THE RESERVE AT CORRAL BLUFFS SUBDIVISION

FILING NO. 3 Construction Drawings El Paso County, Colorado

PCD File No. SF20-7

GENERAL NOTES & TYPICAL SECTION

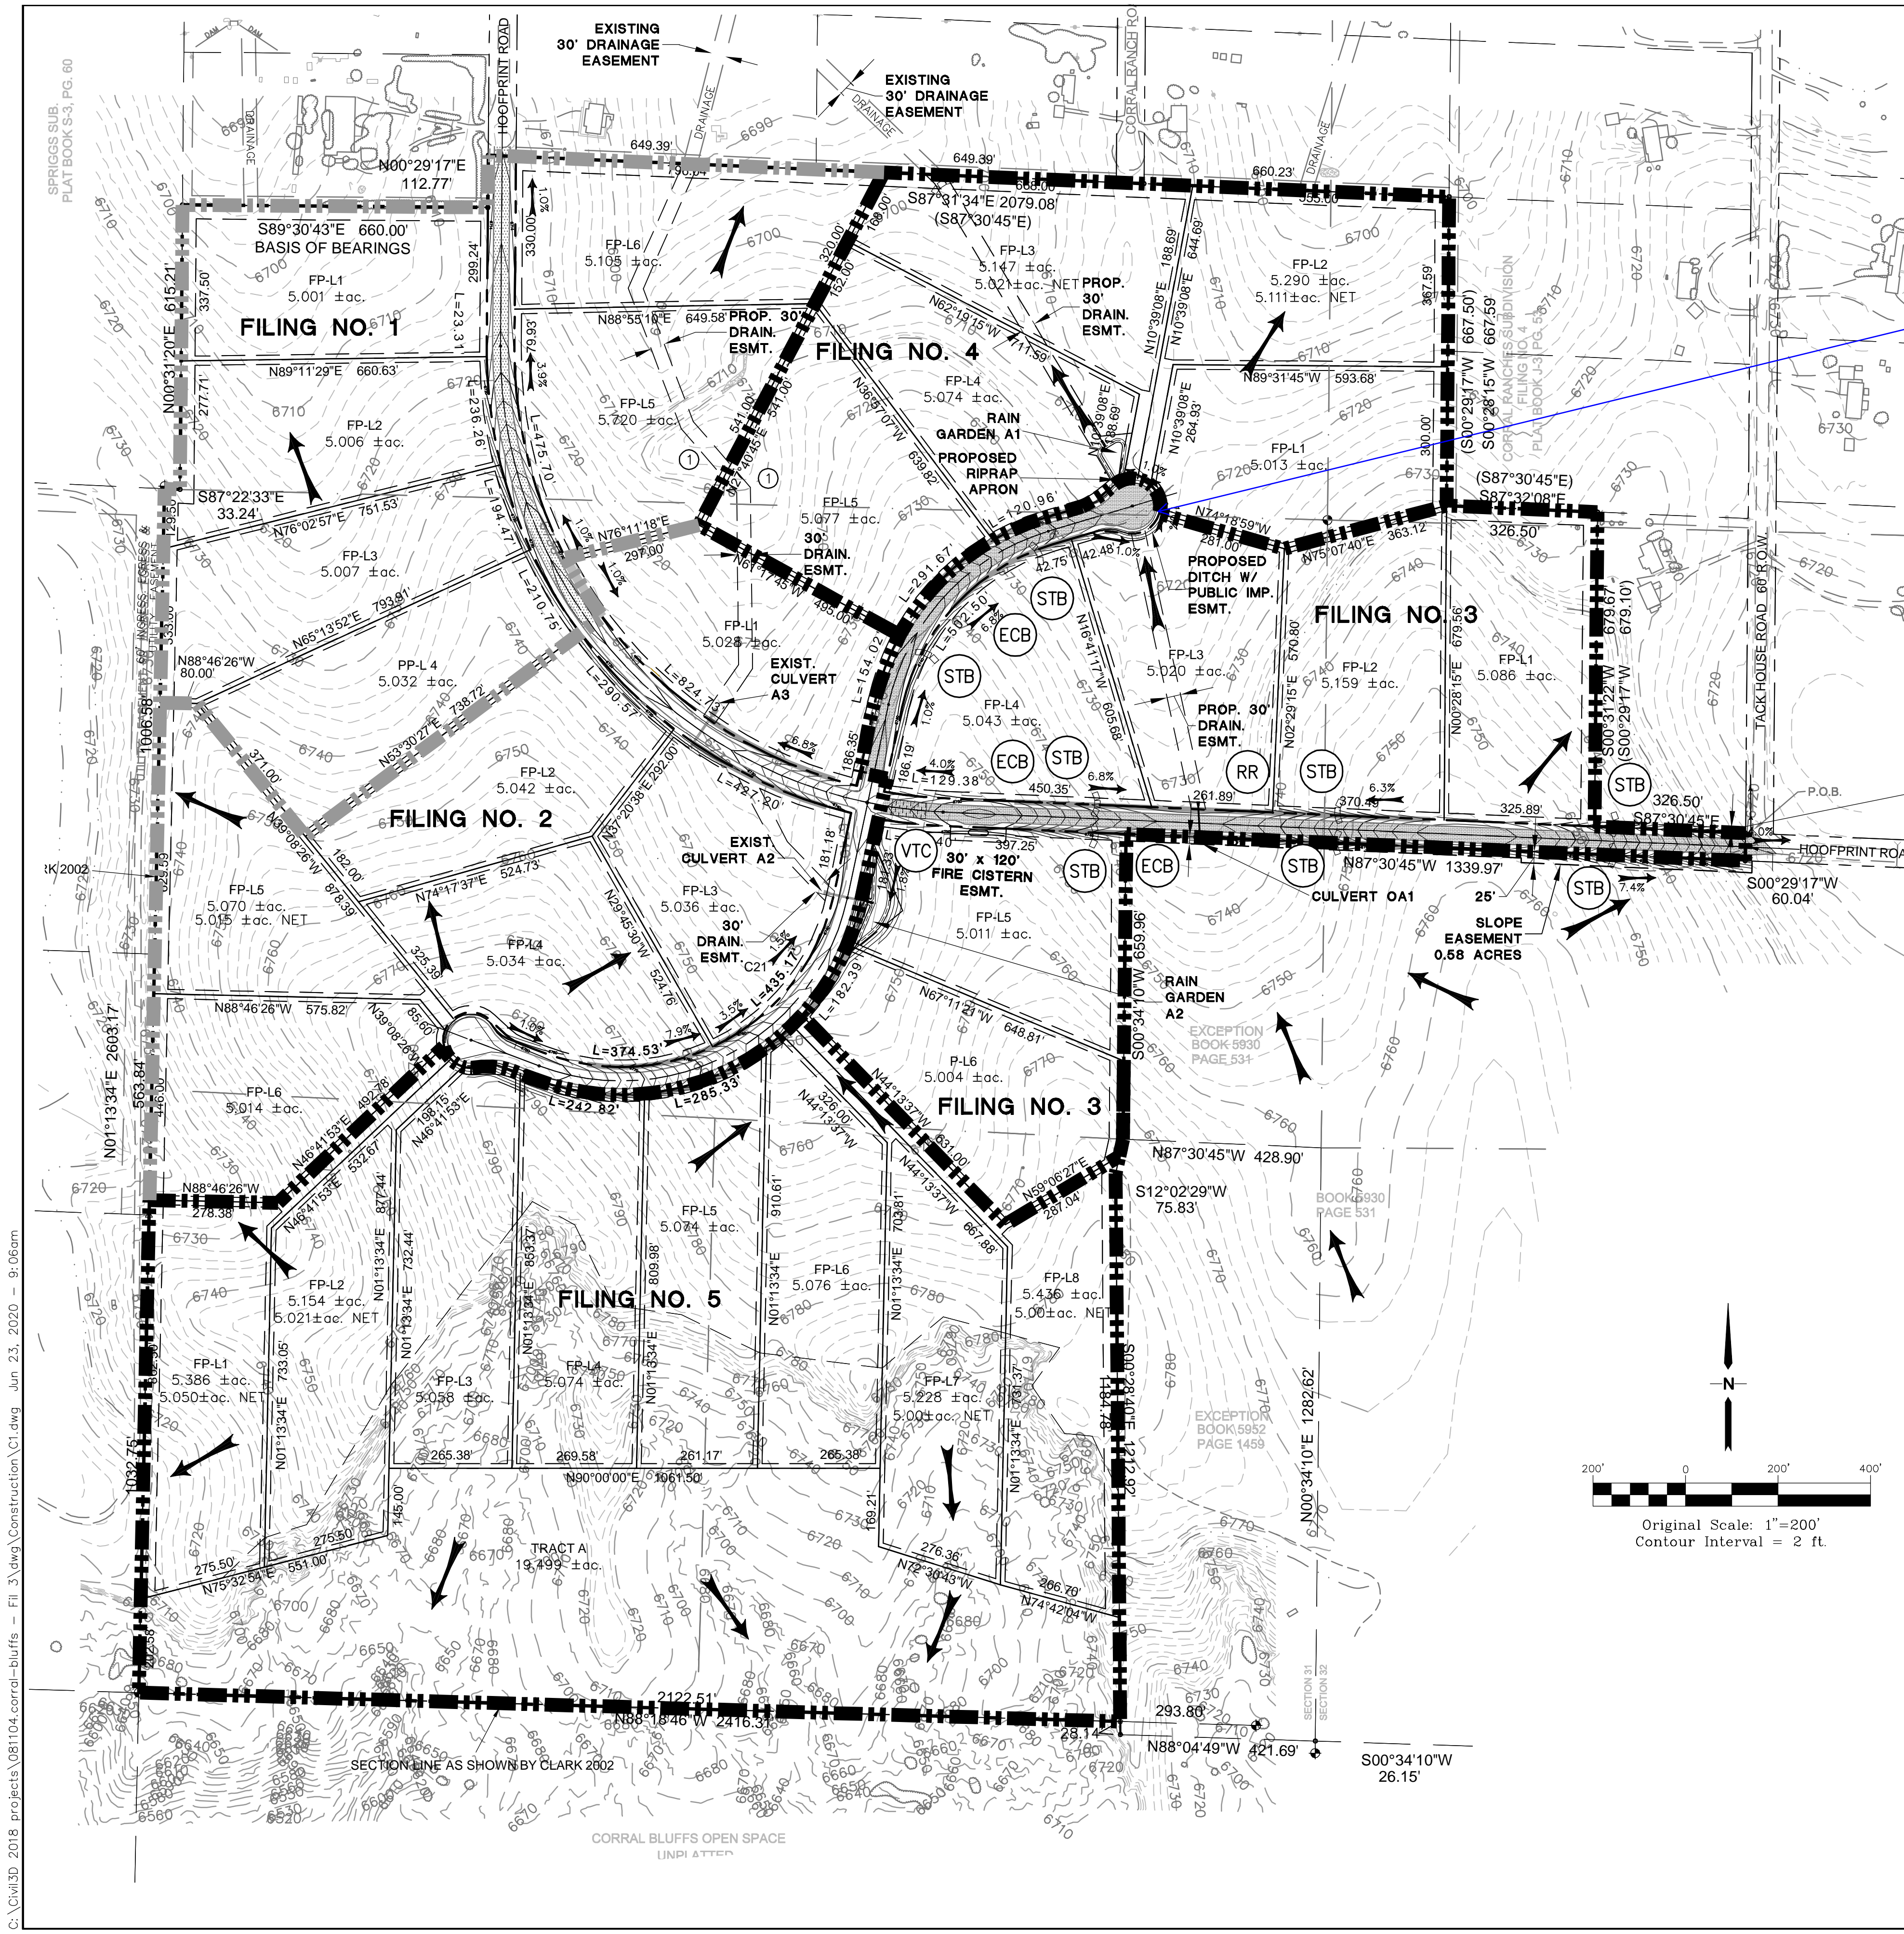
Unresolved.
Change back to the previous callout per the first submittal or provide a 5' Public improvement easement per the standard El Paso County rural local road section (detail SD-2-10). See snippet above. Construction plans must be consistent with the plat.
